Recommendation Report for Planning Permission

REF NO: LU/266/21/PL

LOCATION: 215 Timberleys
Littlehampton
BN17 6QD

PROPOSAL: Erection of 1 No. 4 bed dwelling (resubmission of LU/350/20/PL). This application is in CIL Zone 4 and is CIL Liable as new dwelling.

**PROPOSED GROUND FLOOR AND
FIRST FLOOR PLAN TO NO 215A
TIMBERLEYS**

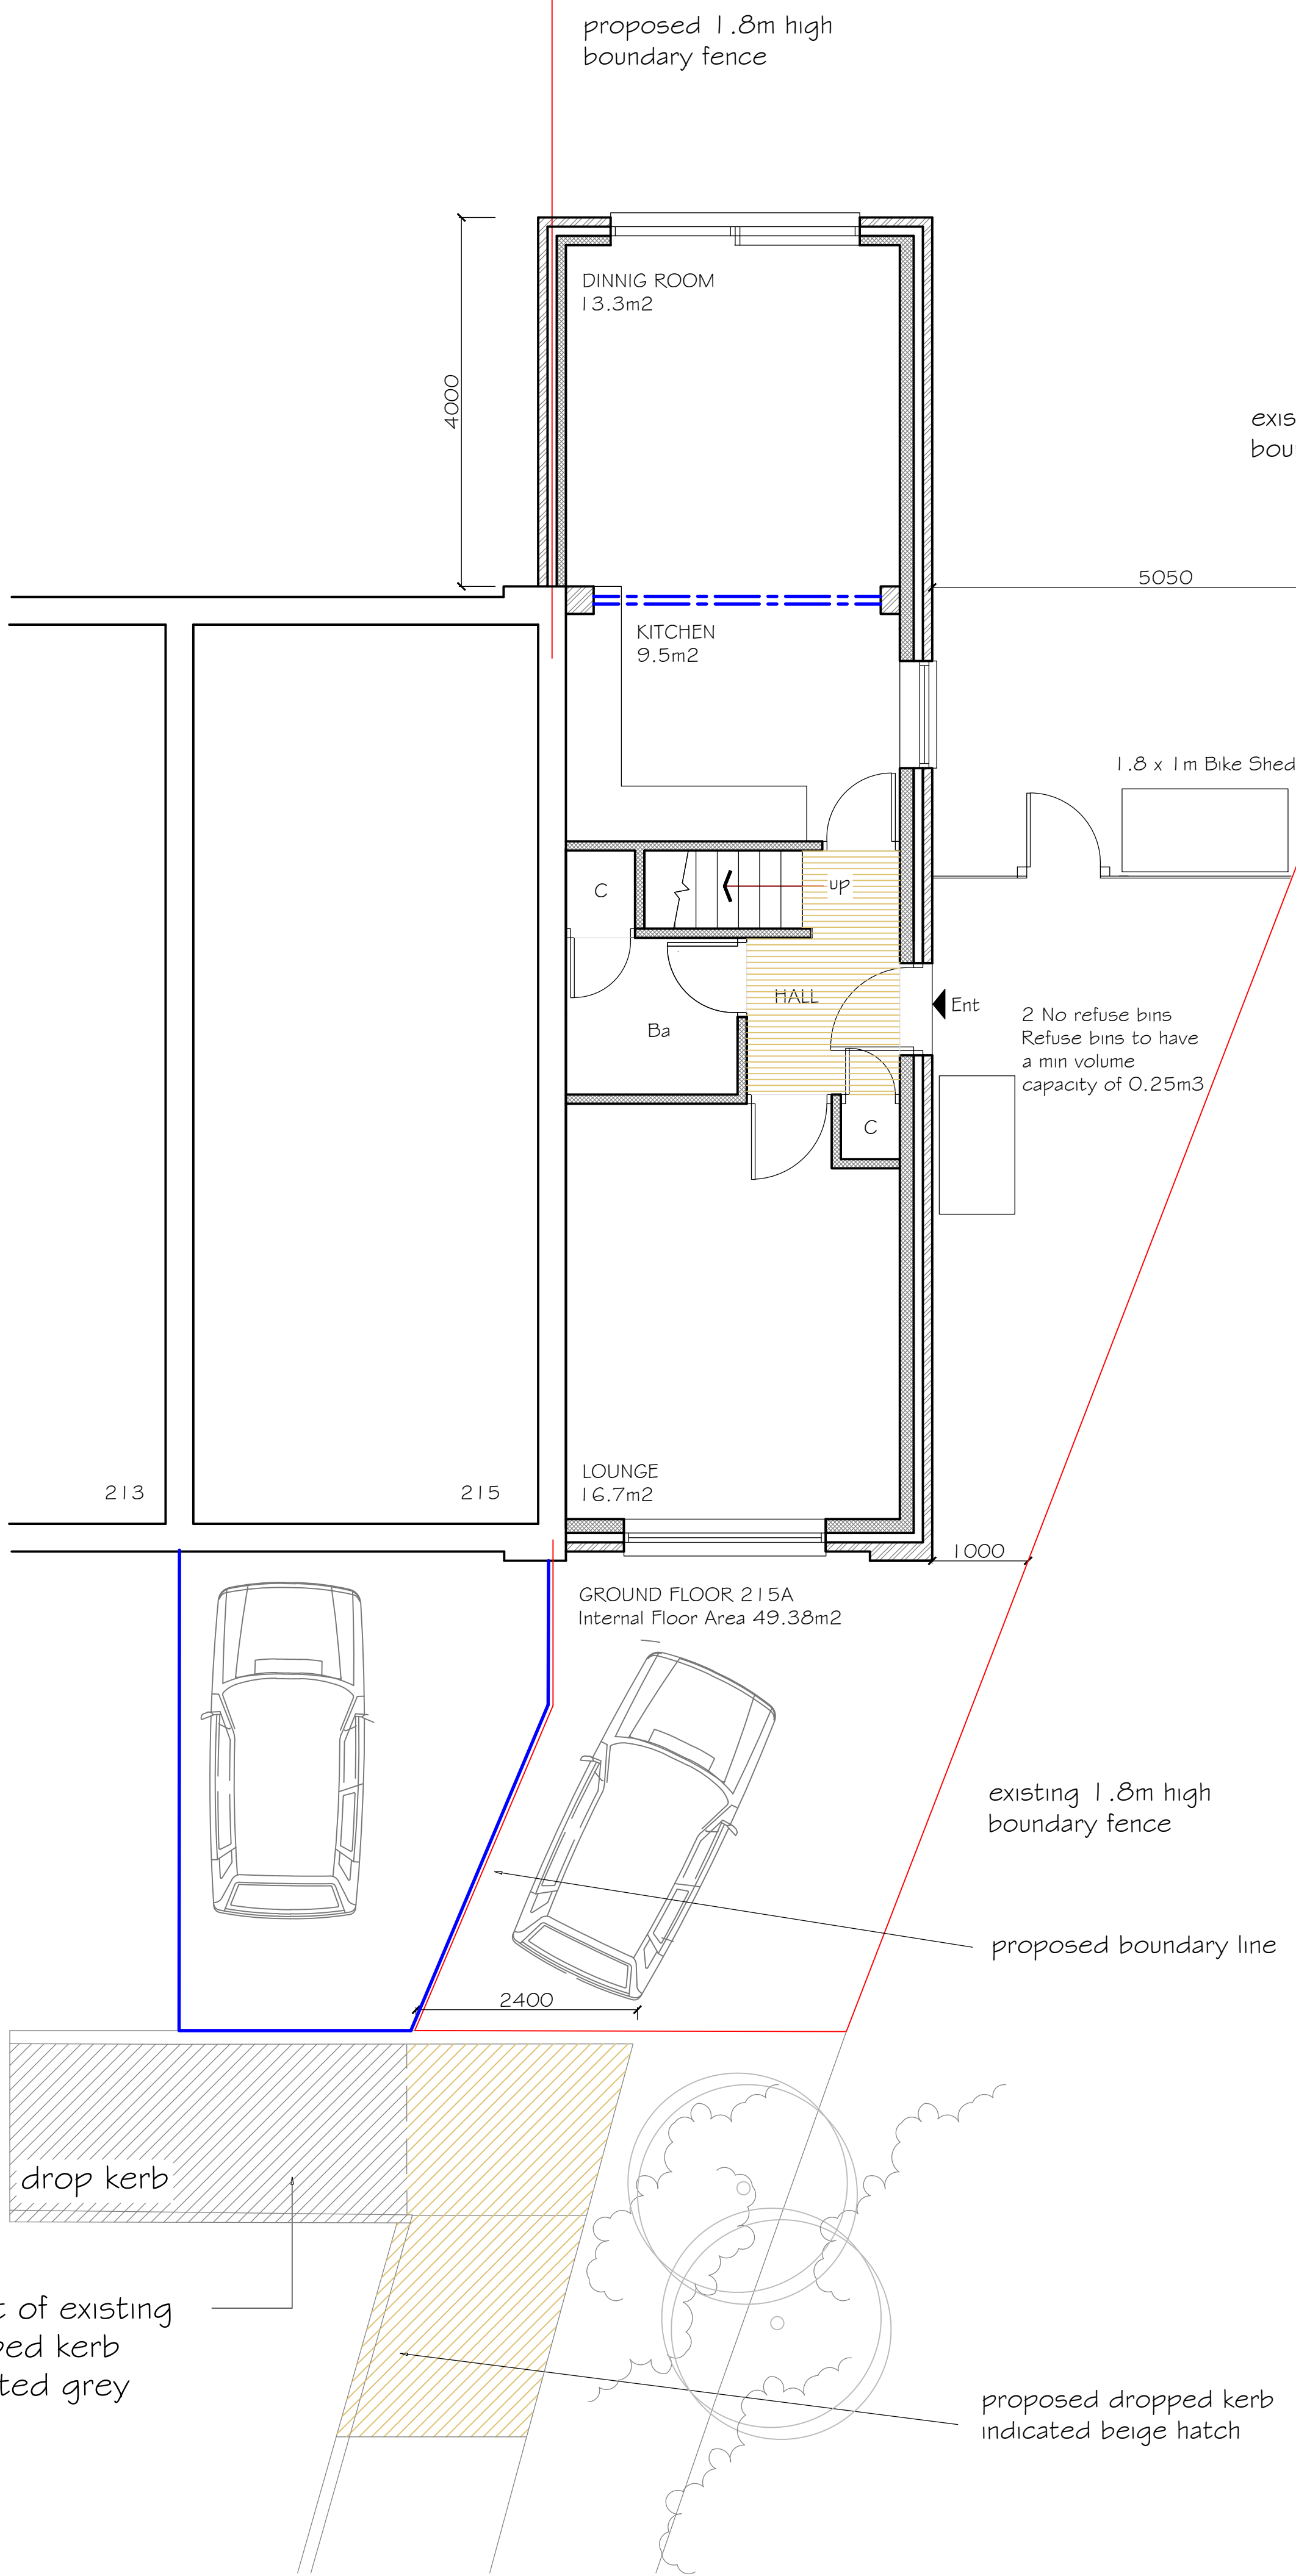
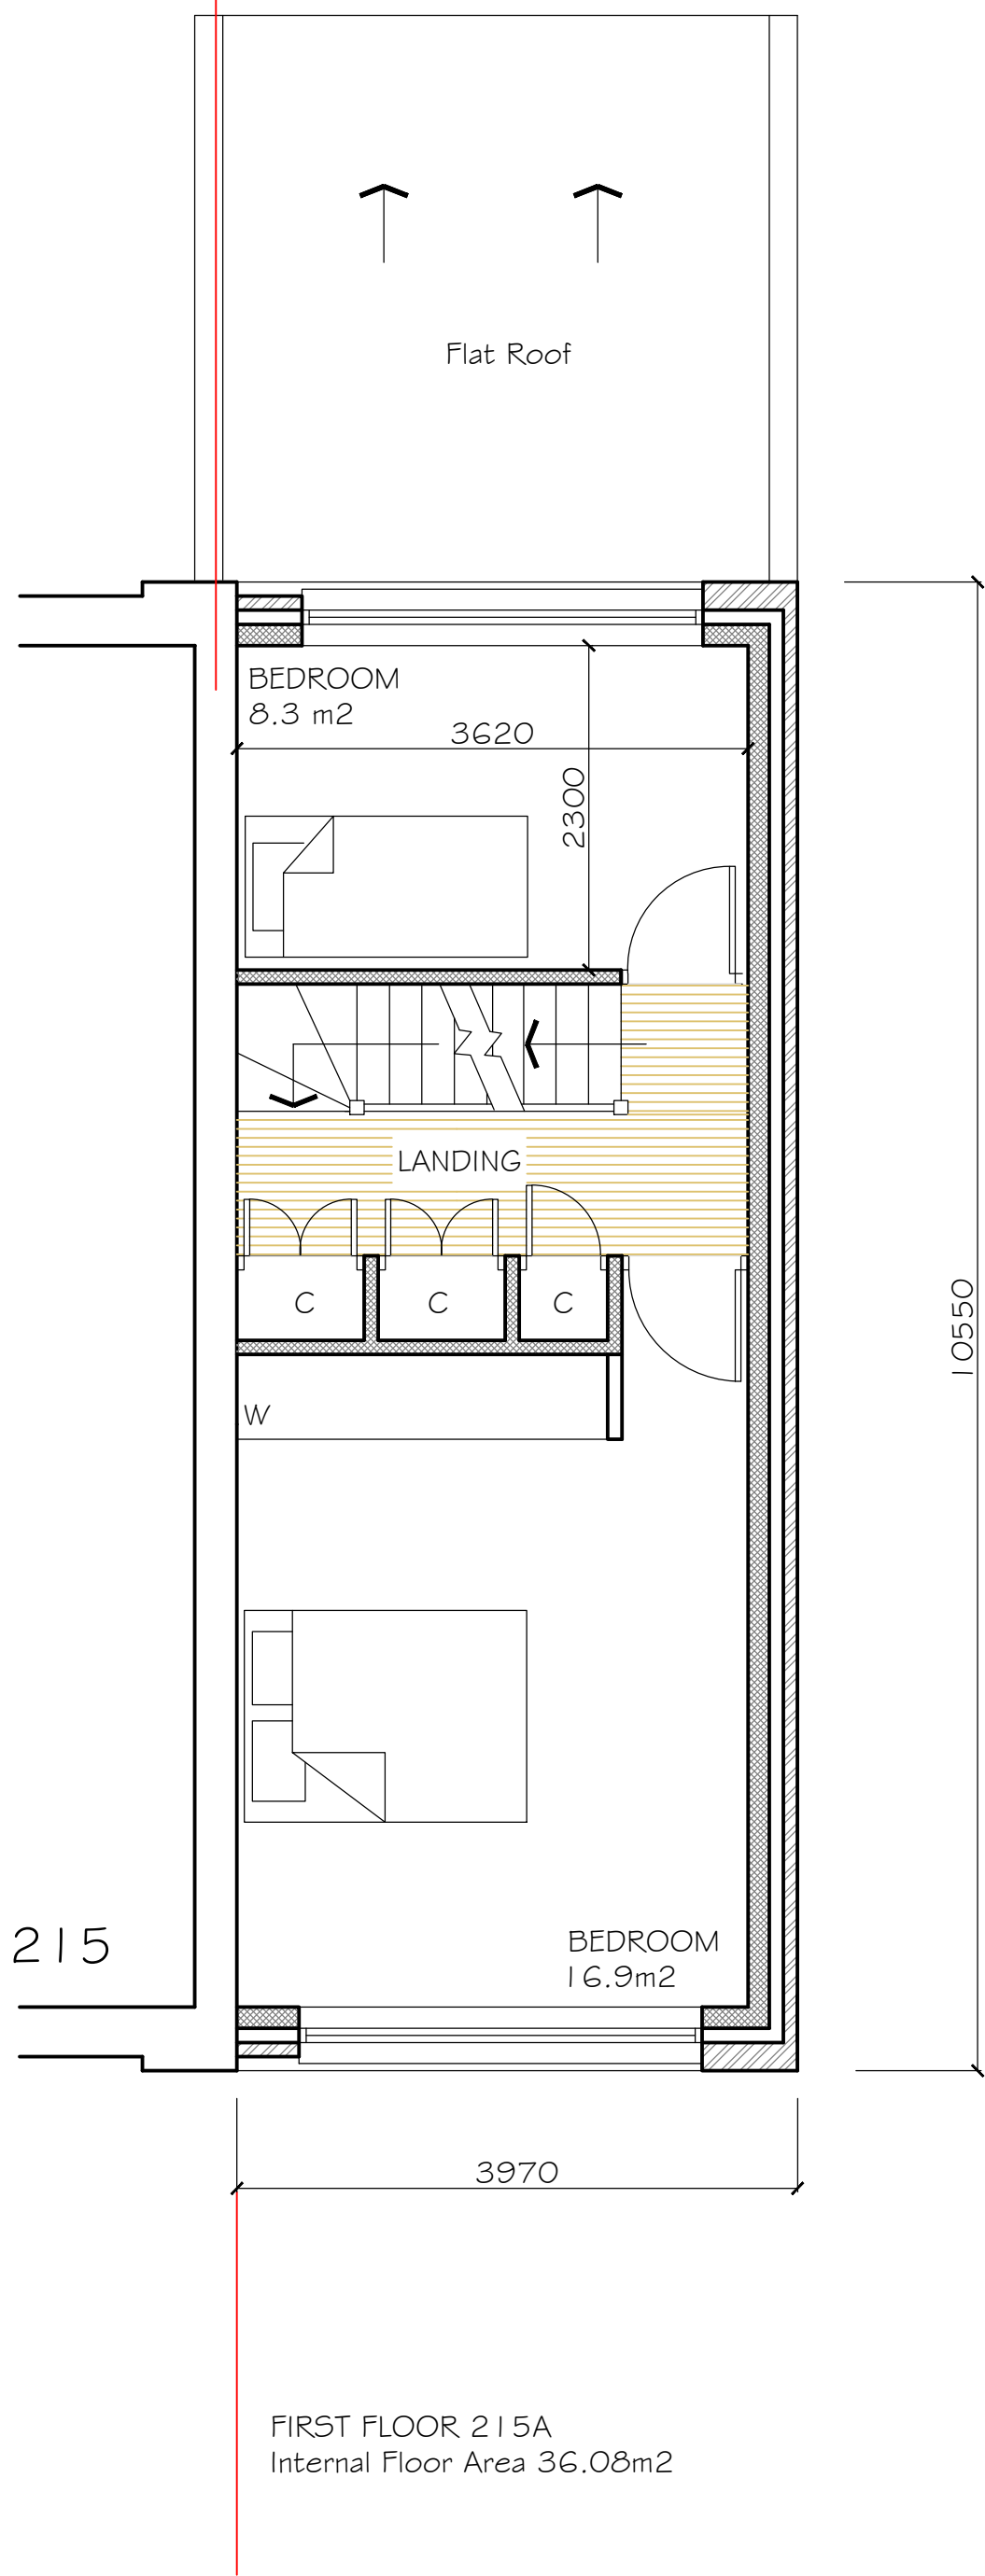
A previous application LU/350/20/PL was approved conditionally at committee. This current application is of a similar nature; however, it proposes a single storey flat roofed rear projection 4m in depth which will provide the occupants with an enlarged kitchen/dining room. The agents have stated that this extension could be built under a Prior Notification Application for a Larger Homes Extension, and this would not receive objections from neighbouring properties, given the fact that the only neighbour would be the current occupiers of 215 Timberleys, who are also the applicants for this application. It is noted that Littlehampton Town Council believe this addition to be an over development of the site. Although it is agreed the extension to the current scheme would not provide a rear garden length in line with Design Guidance recommendations, it is also noted that the property does have the additional side garden space, not afforded to other properties in the terrace, as such this is not considered a reason to refuse this application.

The rear garden would be 6.7m in length and is shorter than other gardens found elsewhere in the area mainly due to the 4m rear extension. Whilst this does not comply design guidance it is noted that this property is afforded with a side garden, which ranges from 1m in width to 5.05m. This additional space is considered to alleviate any issues with the restricted rear garden.

The proposed development would not project forward of No. 215 Timberleys, nor others in the terrace. However, the rear protrusion of the proposed dwelling does infringe on the 45-degree rule for rear extensions and conflicts with Part P of the Arun Design Guide. It is believed that this protrusion (extension), which will be built up to the party wall line shared with No 215, will be overbearing on the future occupiers of this space and create an unsatisfactory relationship between both dwellings. As stated within the application documents, when the property is built it will be afforded Permitted Development Rights and the applicants could provide an extension to the rear of the property of up to 3m in depth. However, this does not automatically include the right to build a Larger Homes Extension under a Prior Notification, which an extension of this size would require. To be allowed such an extension the due process of a Prior Notification Application should be undertaken, rather than gaining the extension by default as part of this application.

However, the overbearing nature of the proposal will have an unacceptable impact on residential amenity of the neighbouring property by creating overshadowing, and therefore be in conflict with policy D DM1 of the Arun Local Plan.
